Ferring Parish Council

Your Ref: OWPC15710
Our Ref: FG/139/17/PL
Please ask for:
Mrs A Gardner

Replacement monopole & antennas & 1 No. replacement cabinet.
Existing Telecommunications Installation Ferring Water Pumping Station off Amberley
Drive Ferring

Photomontage Portfolio

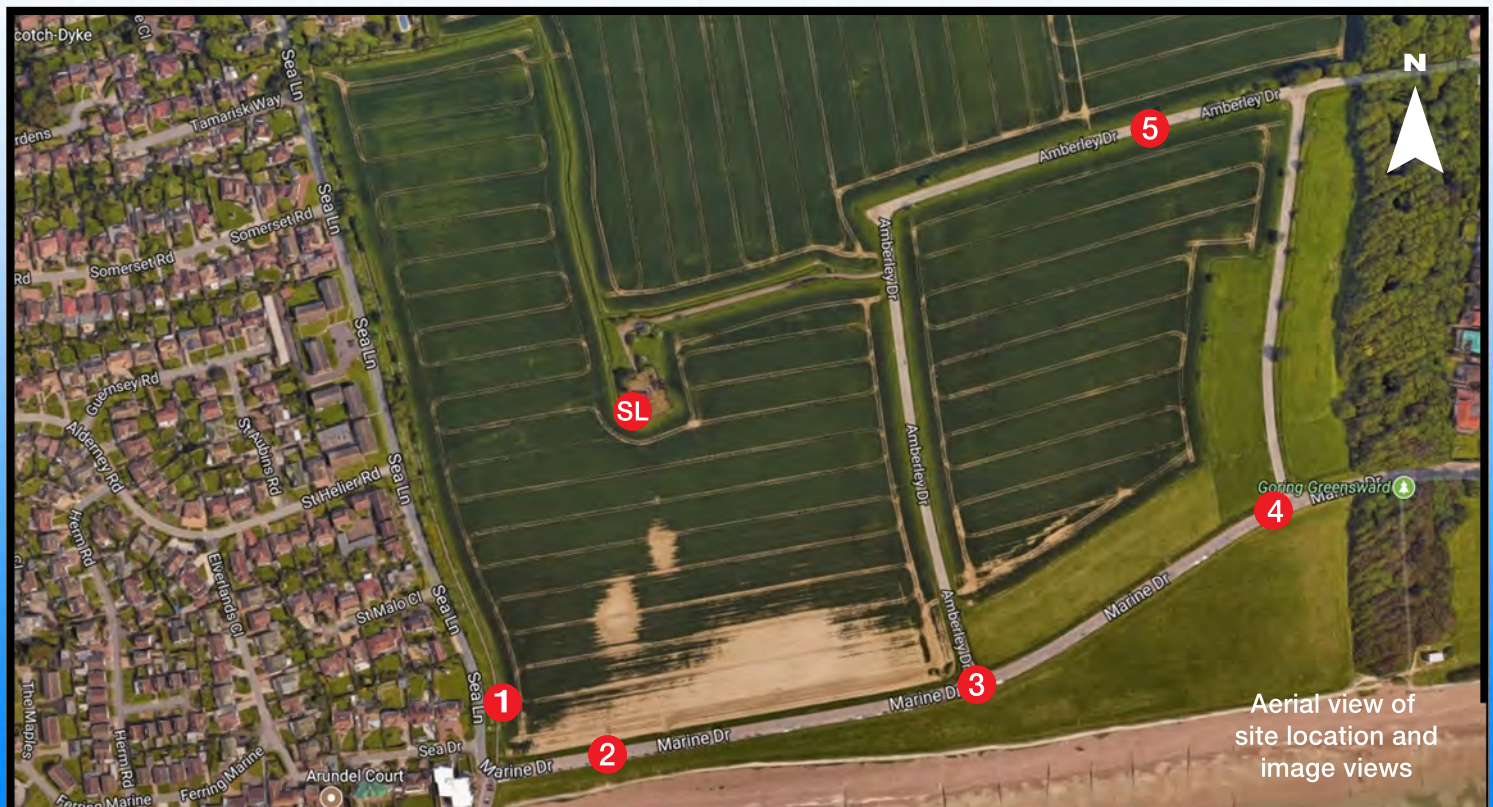
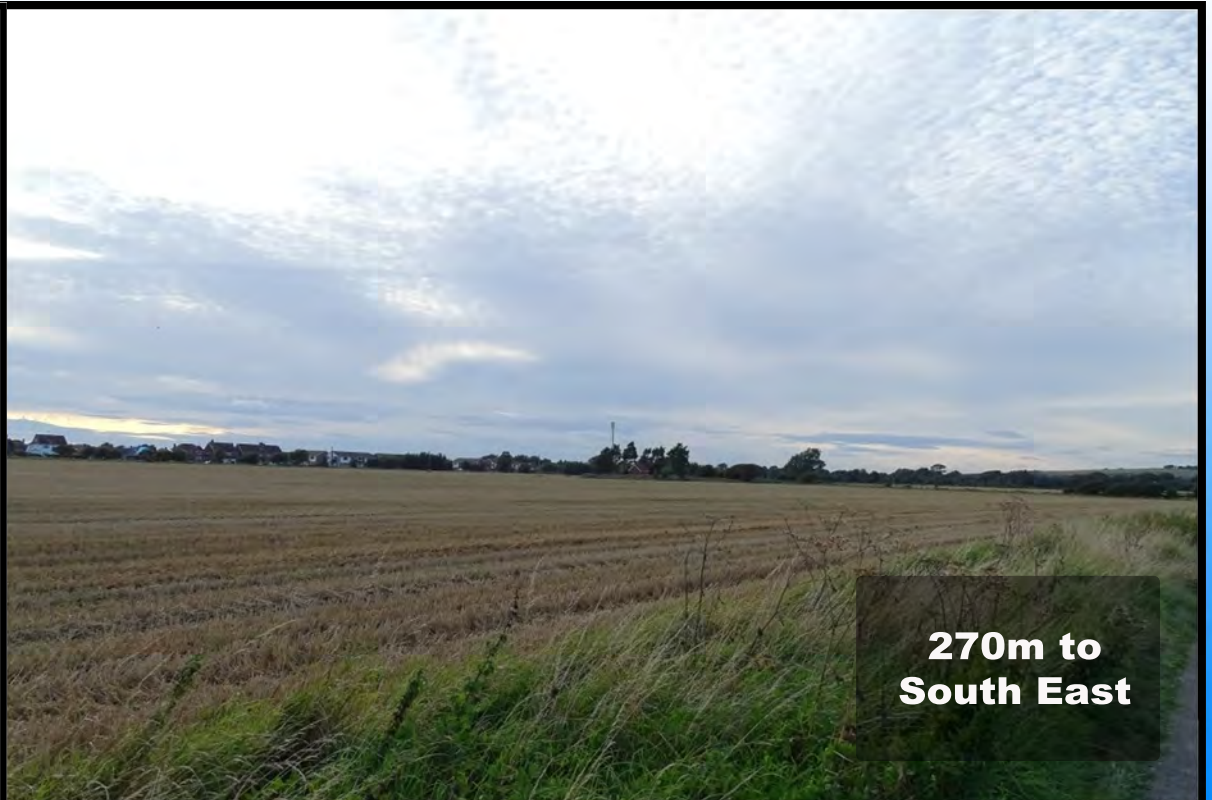
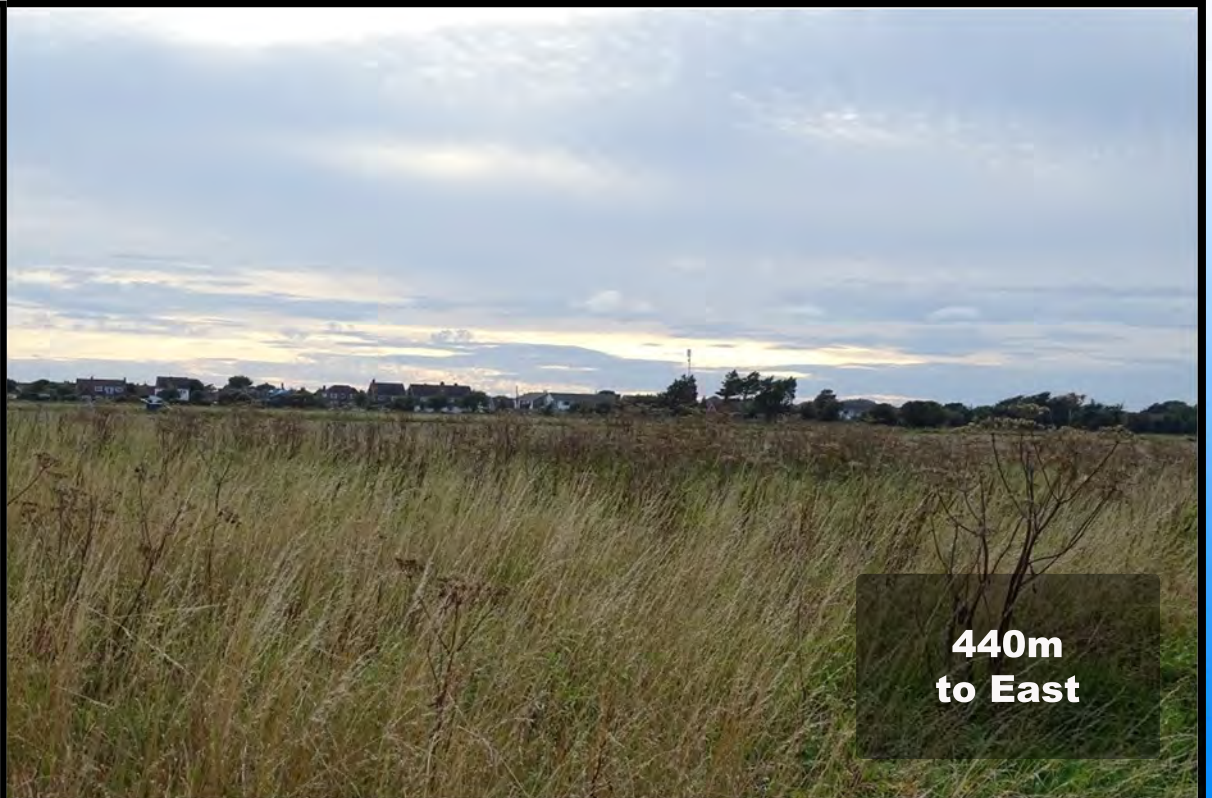
The proposed mast will be a significantly greater visual impact and very intrusive in a rural area.

PROPOSED ELEVATION

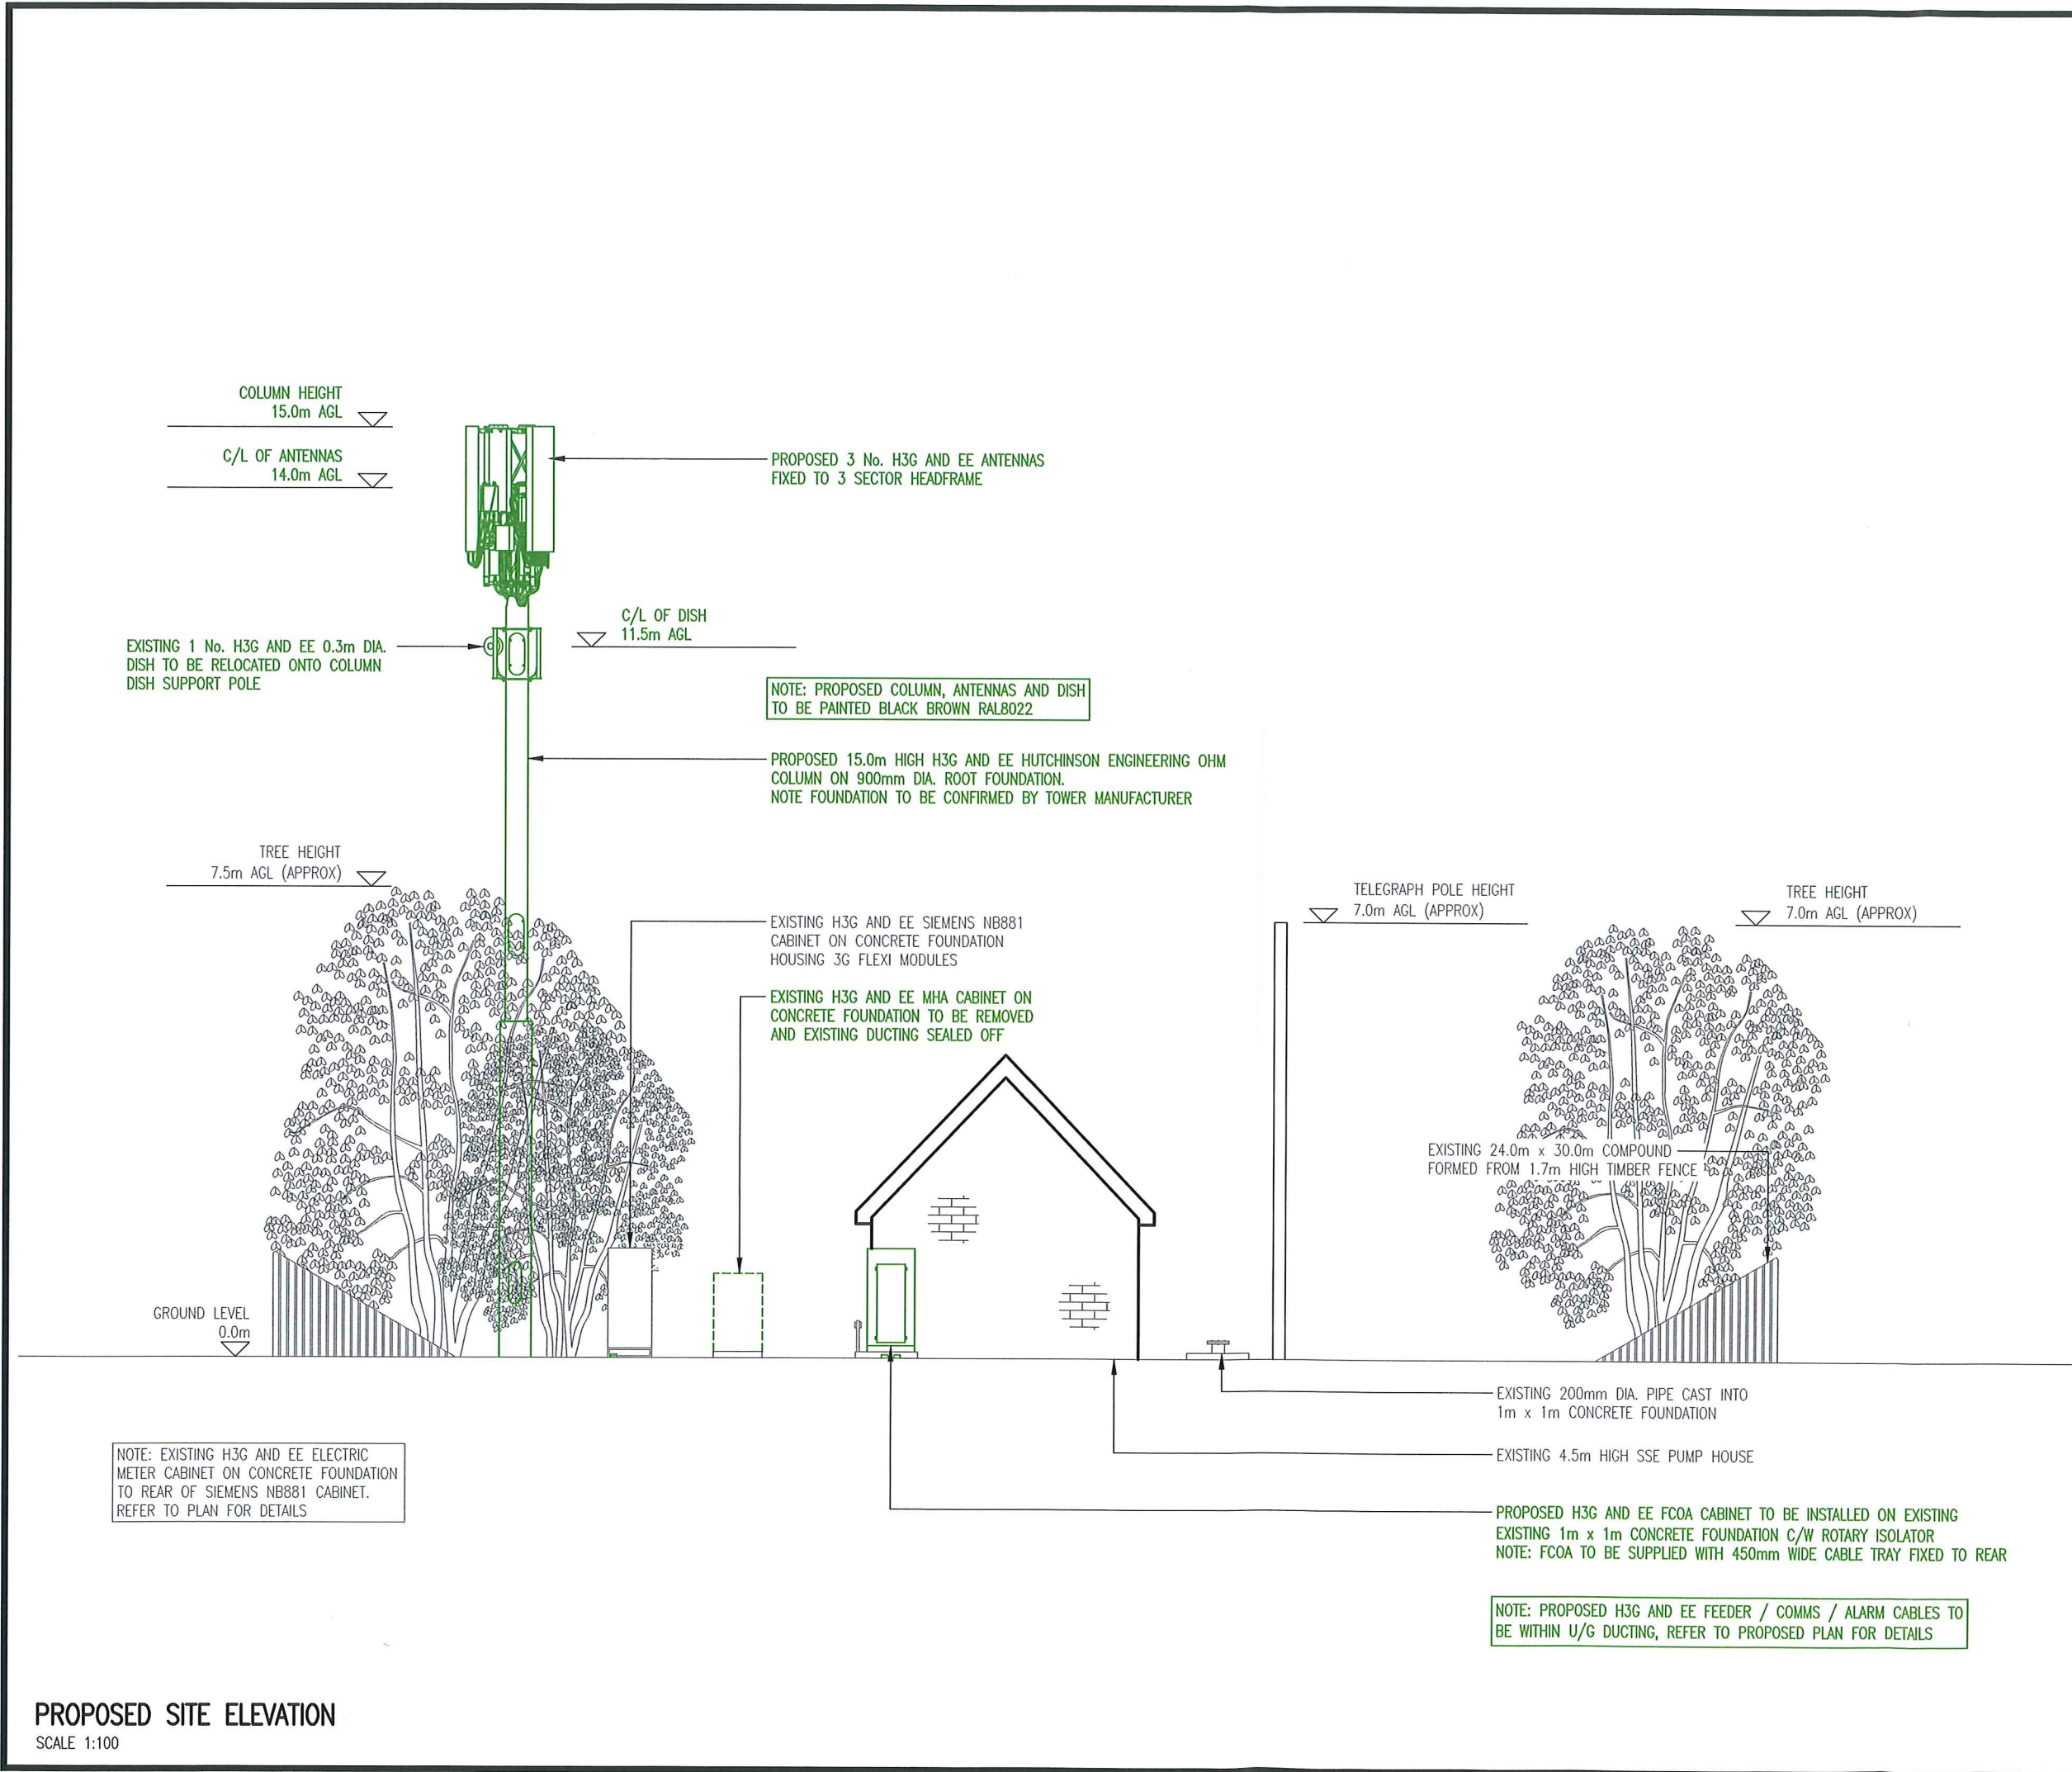
Ferring Parish Council was indeed consulted by the applicant with regards to this application earlier this year and we raised concerns regarding the height of the proposal to replace existing 12m monopole with a new 15m monopole.

Whilst we appreciate that upgrades may be necessary to meet technological advances but we do not consider that to be 15 metres in the air when tree management could confine this to the current mast height.
